AN AMENDMENT TO CLAREMONT COMMERCIAL FILING NO. 2

PRELIMINARY PLAN

CLAREMONT BUSINESS PARK

PRELIMINARY PLAN

Land Planning
Landscape Architecture
Urban Design

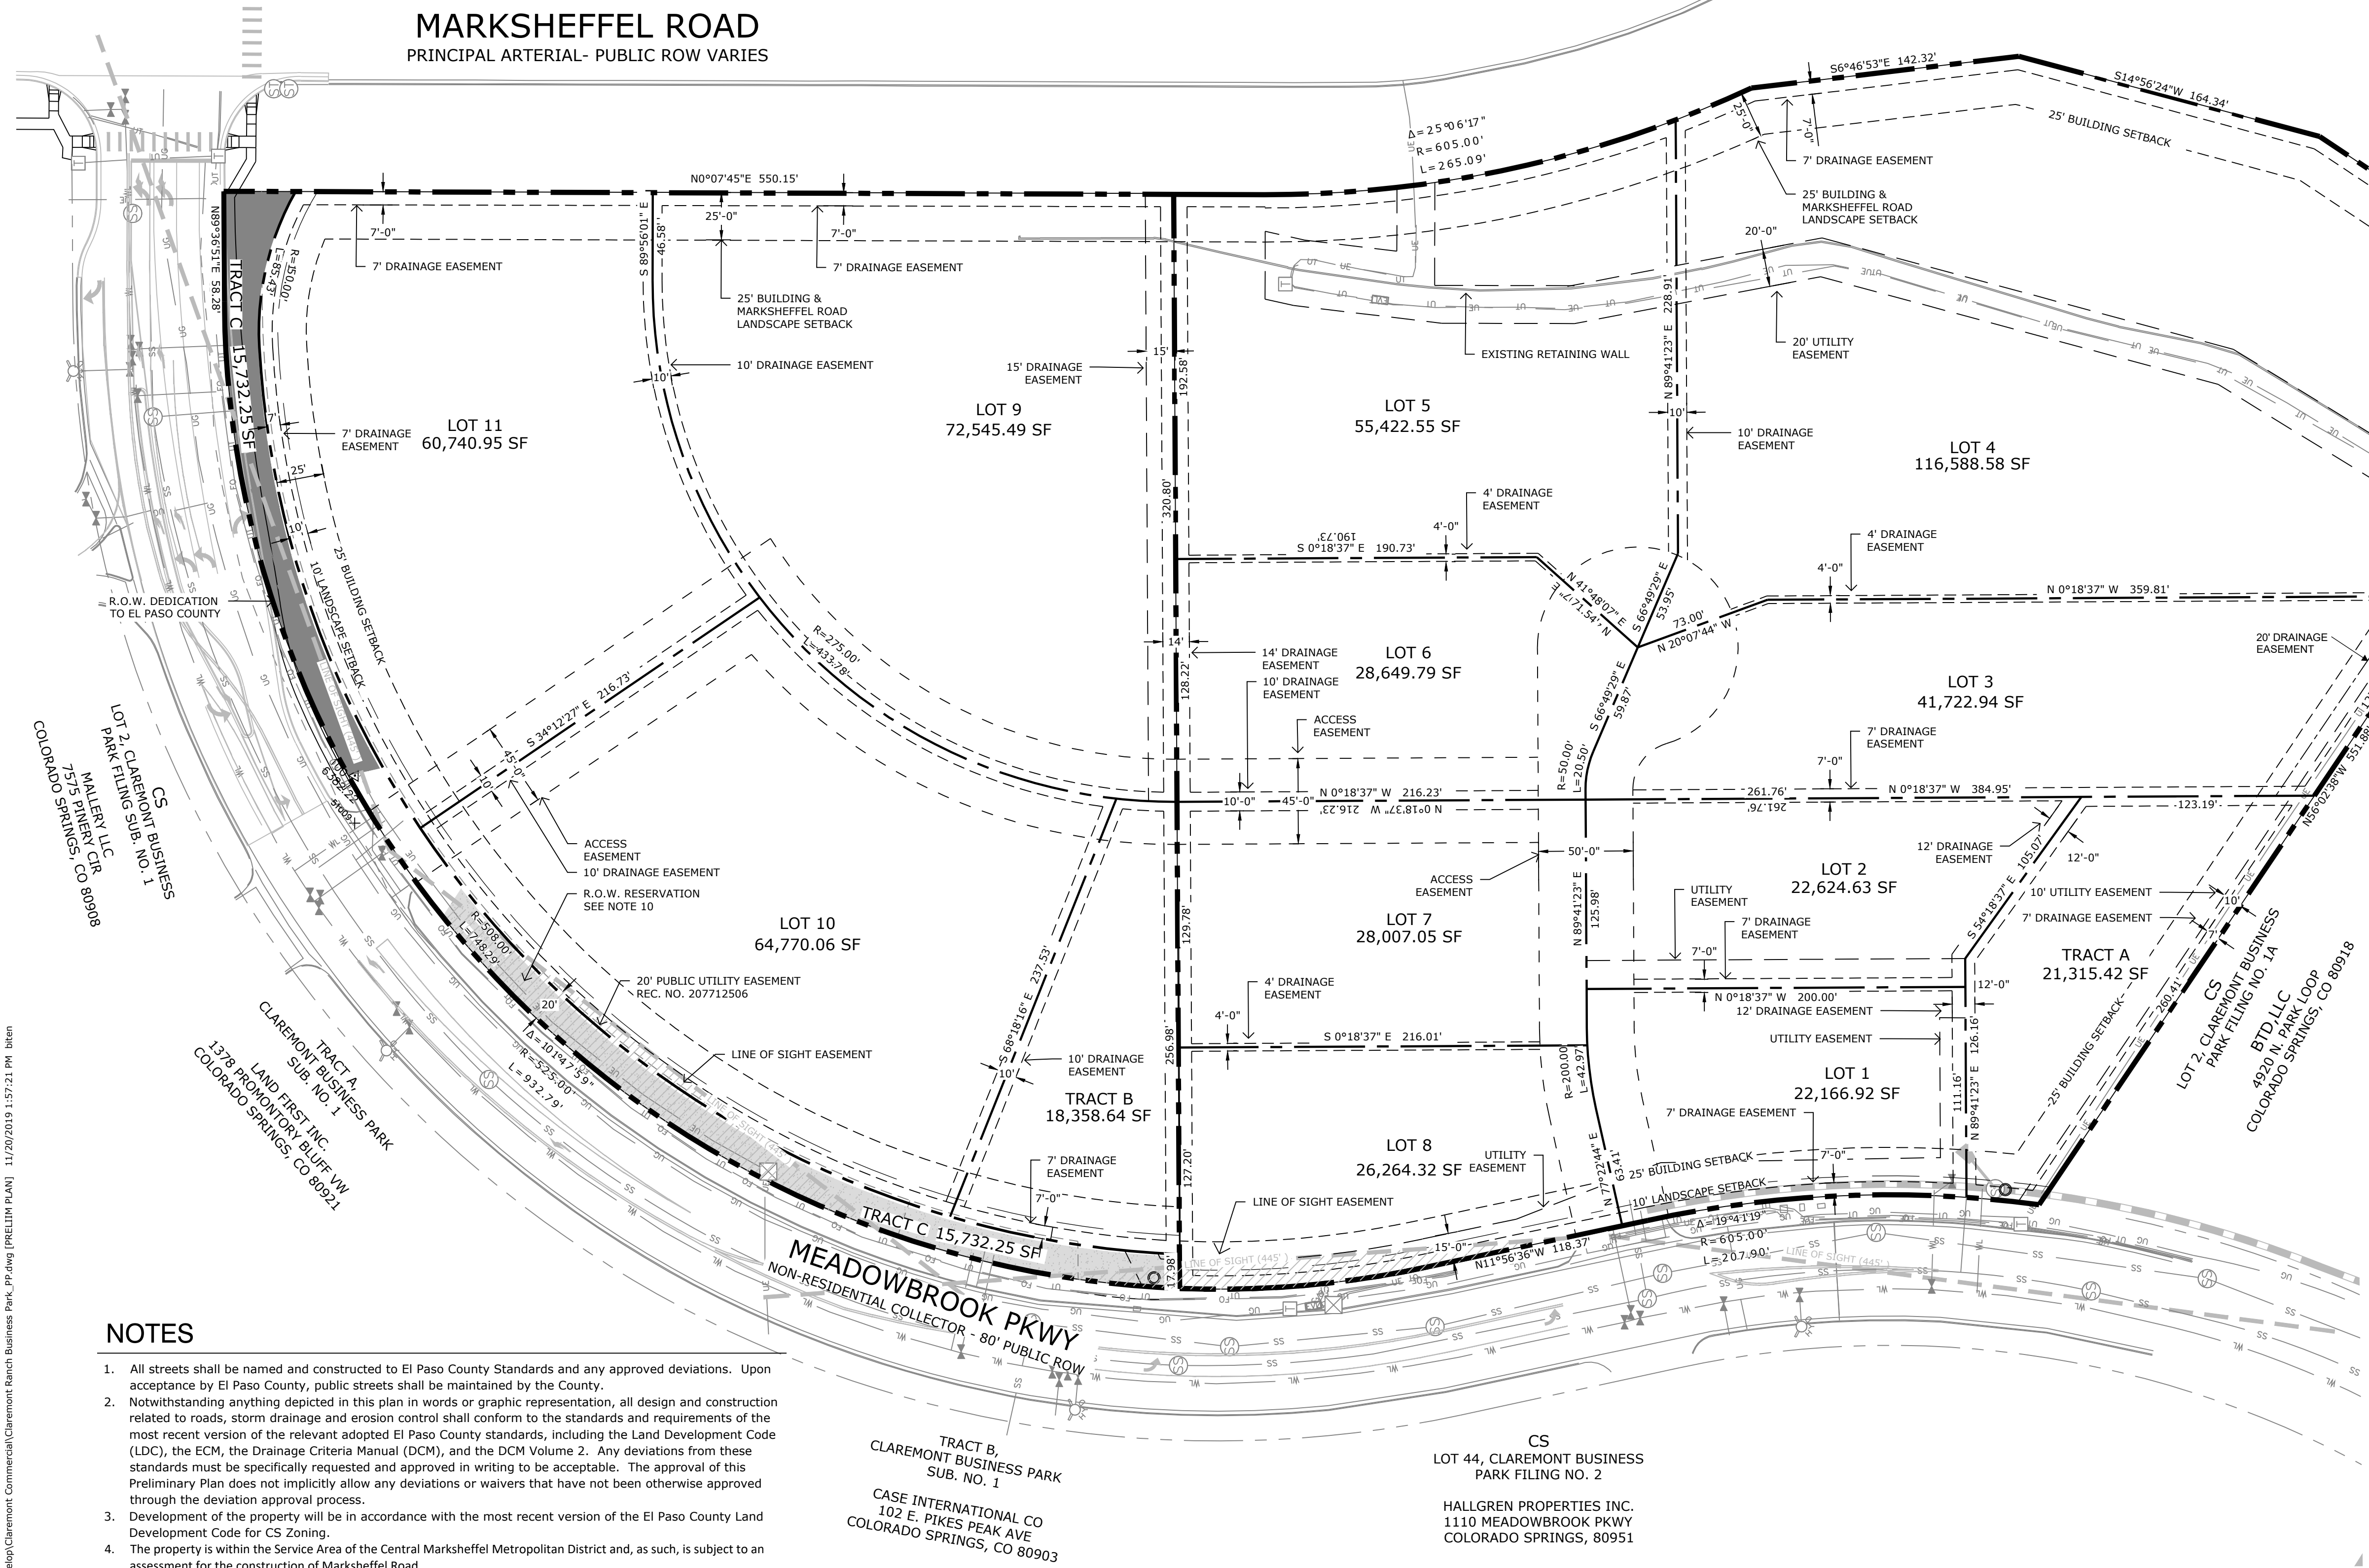
Review 1 comment:
 As currently shown the ROW reservation is part of tract C not Lot 9. If the intent is for this reserved area to remain within lot 9 until requested by the County, then revise the property line, easement lines, distances etc. for lot 9 accordingly. Similarly, address the area in front of tract B so that it is clear what your intent is.
Review 2: Unresolved.

Review 1 comment:
 Add PCD File No. SP197
Review 2: Unresolved.
